OBSERVATION/SUBMISSION TO PLANNING APPLICATION

Case Reference: 323761

Re: Observation/Submission to proposed wind energy development at Cooloo Wind Farm

Applicant: Neoen Renewables Ireland Limited

PROJECT TITLE: Cooloo Wind Farm, Co. Galway			
DRAWING TITLE: Site Layout Plan Sheet 1 of 7			
PROJECT No.: 190723	DRAWING No.: 190723 - 07	SCALE: 1:2,500 @ A1	
DRAWN BY: JOB	CHECKED BY: RD	DATE: 24.09.2025	REVISION: P01
OS SHEET No.: 2816, 2817, 2884, 2885, 2953, 2954

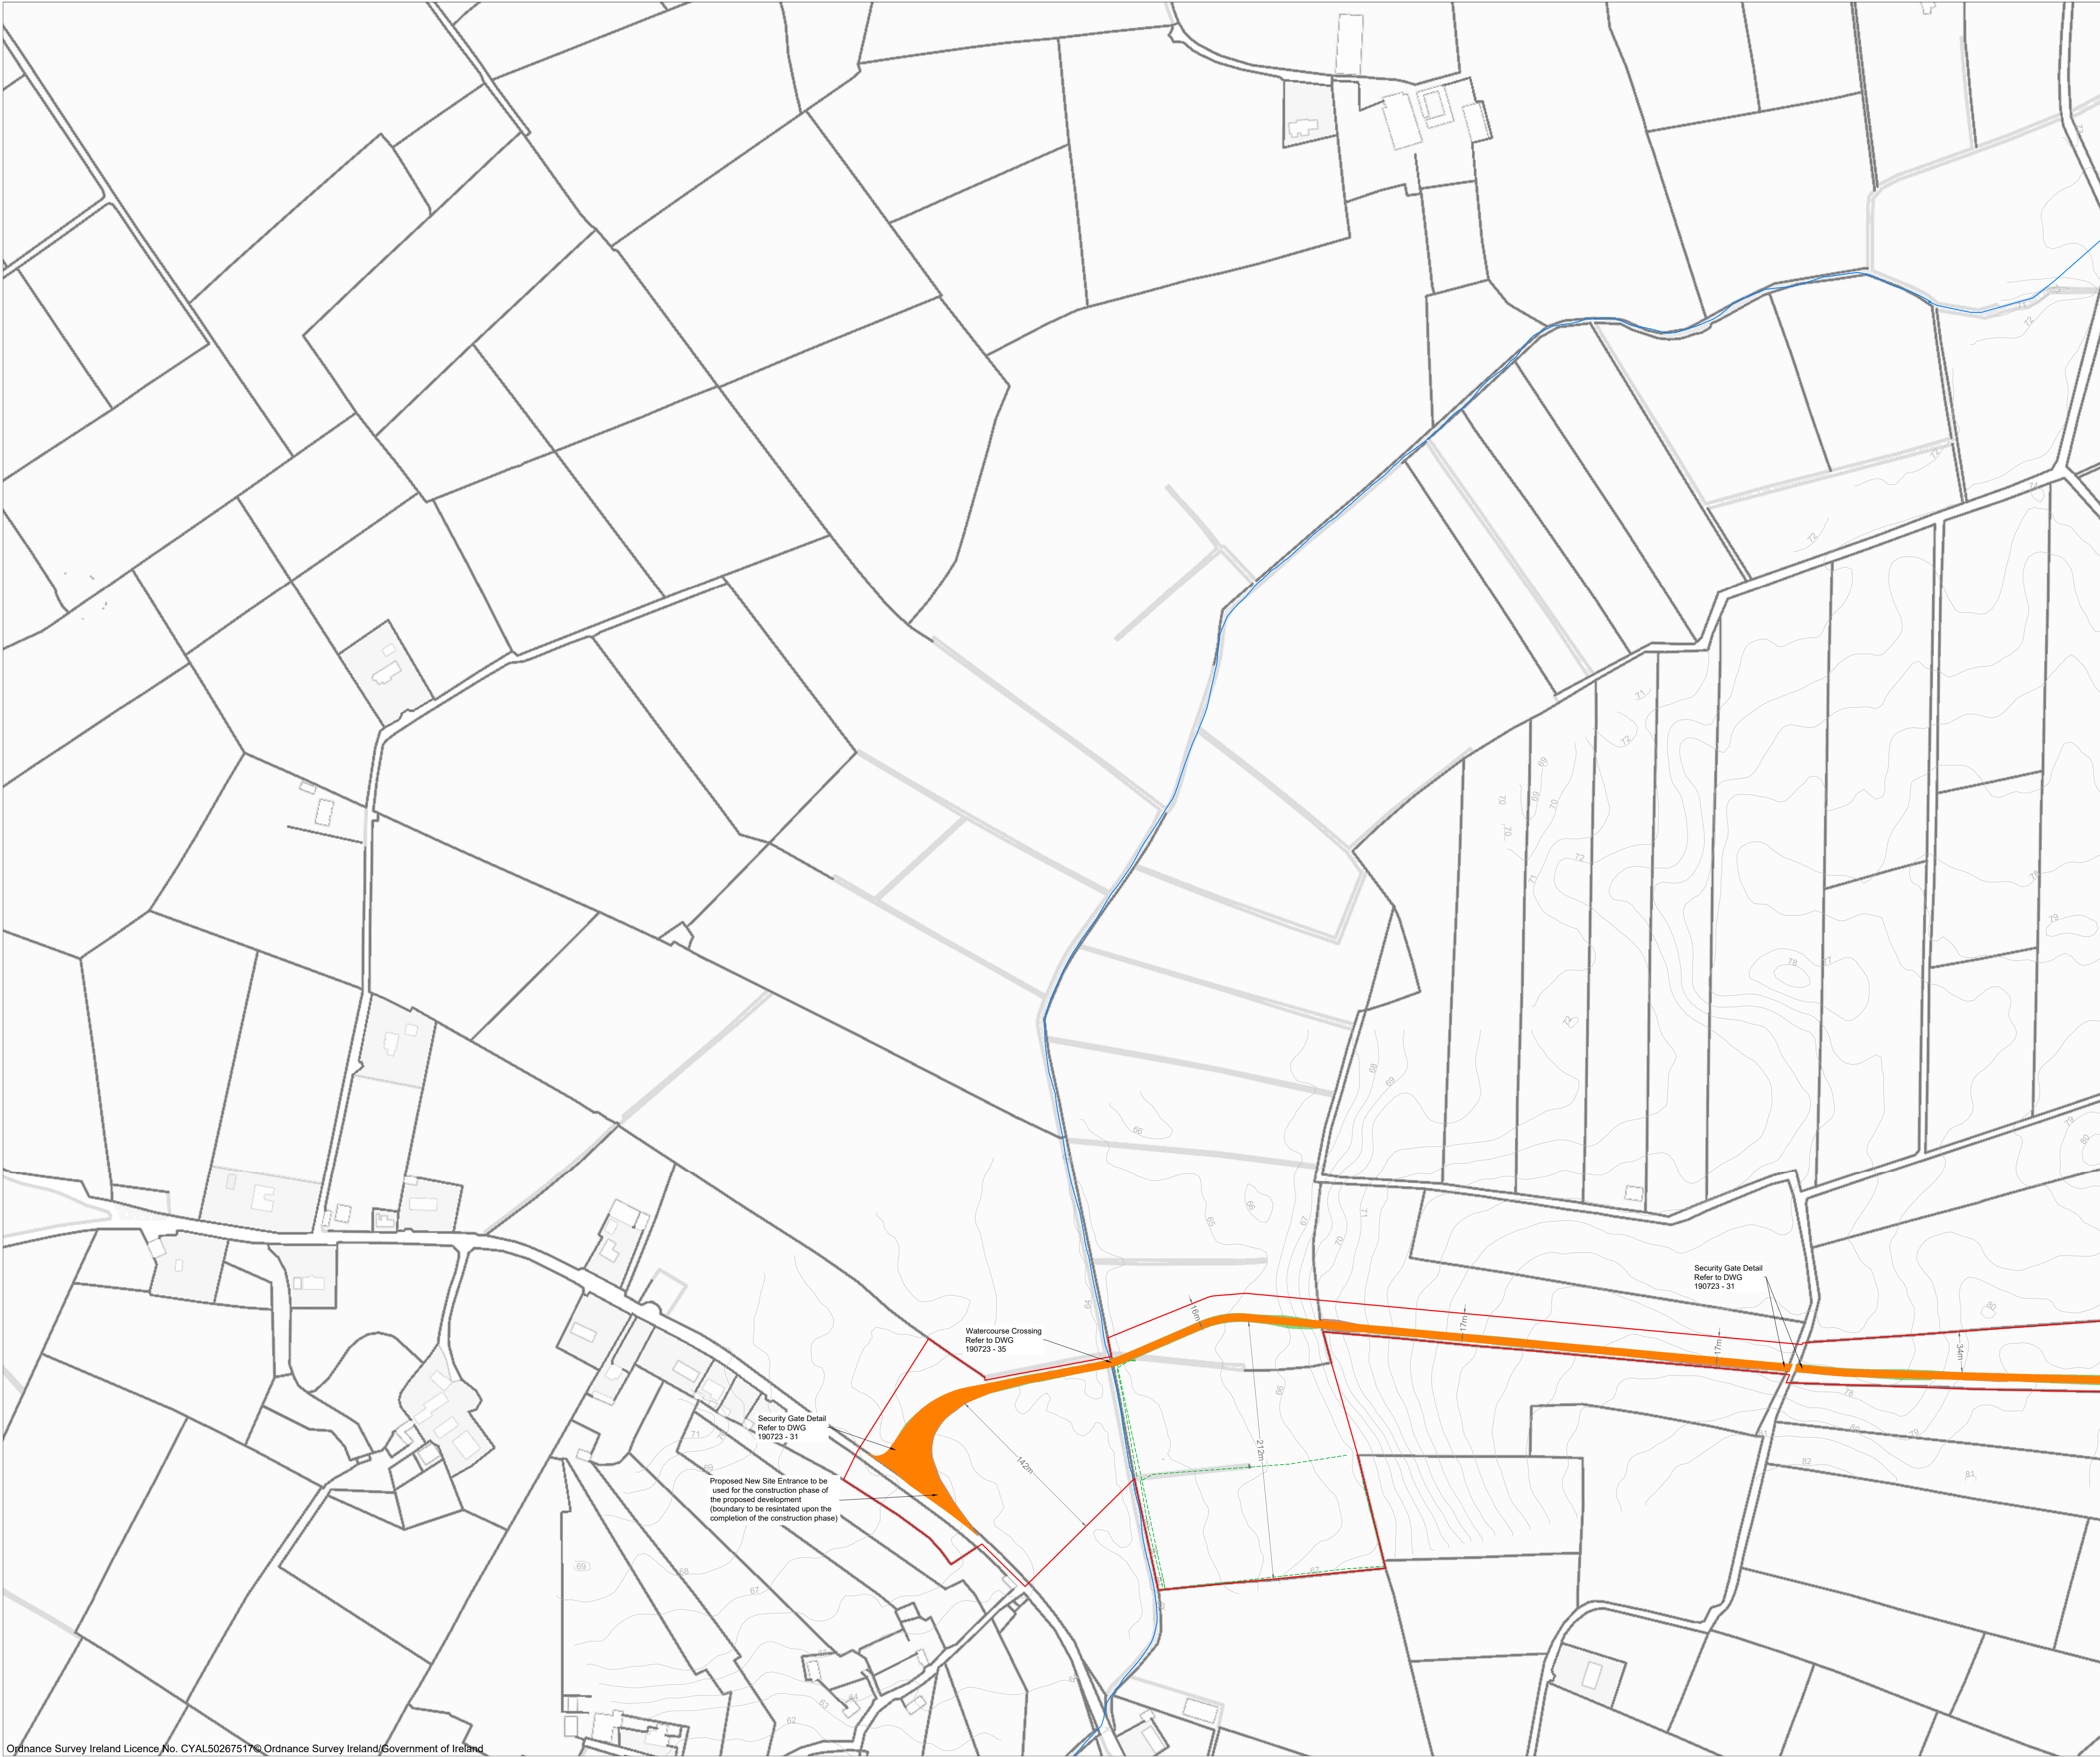
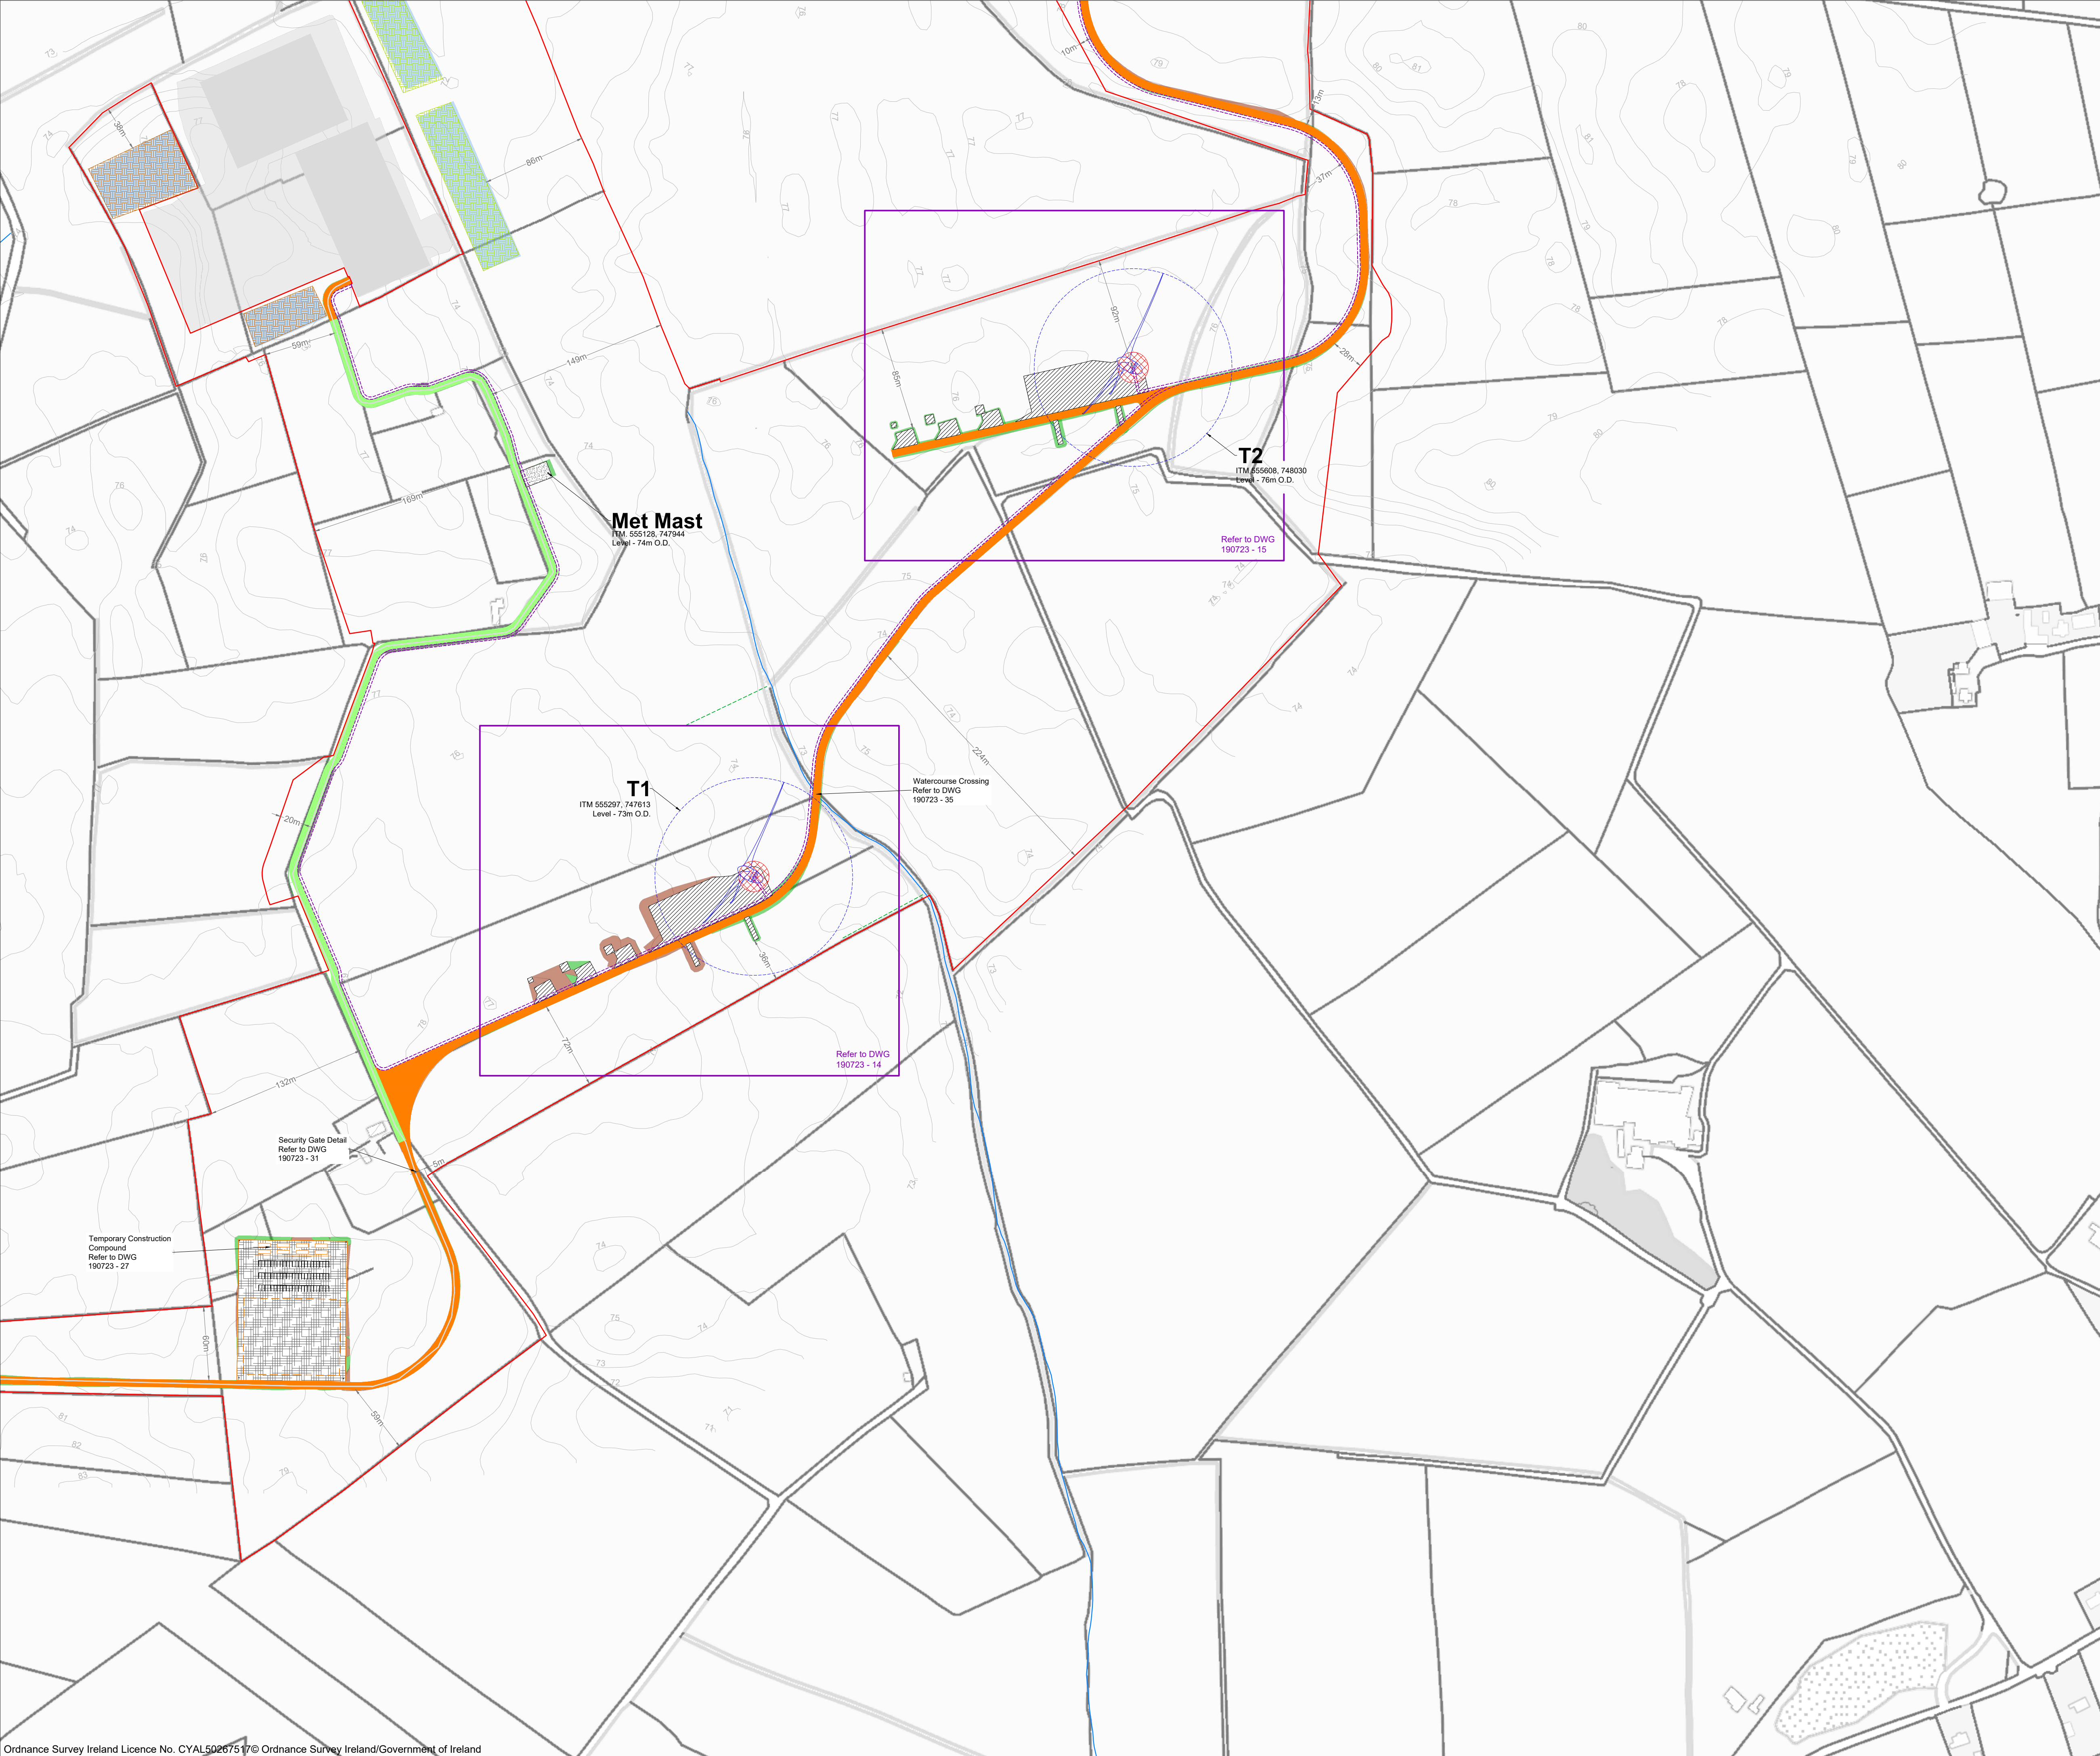
The project's Environmental Impact Assessment Report (EIAR) acknowledges a residual adverse effect on Degraded Raised Bog (habitat 7120), a habitat of County Importance with capacity for natural regeneration (EIAR Ch. 6, p. 142). Construction of the proposed floating access road between turbines T7 and T9 will directly remove approximately 0.18 ha of this sensitive peatland and disrupt its hydrological balance (EIAR Ch. 6, Sec. 6.5.2.1.1). This is contrary to the conservation obligations set out under the EU Habitats Directive (92/43/EEC).
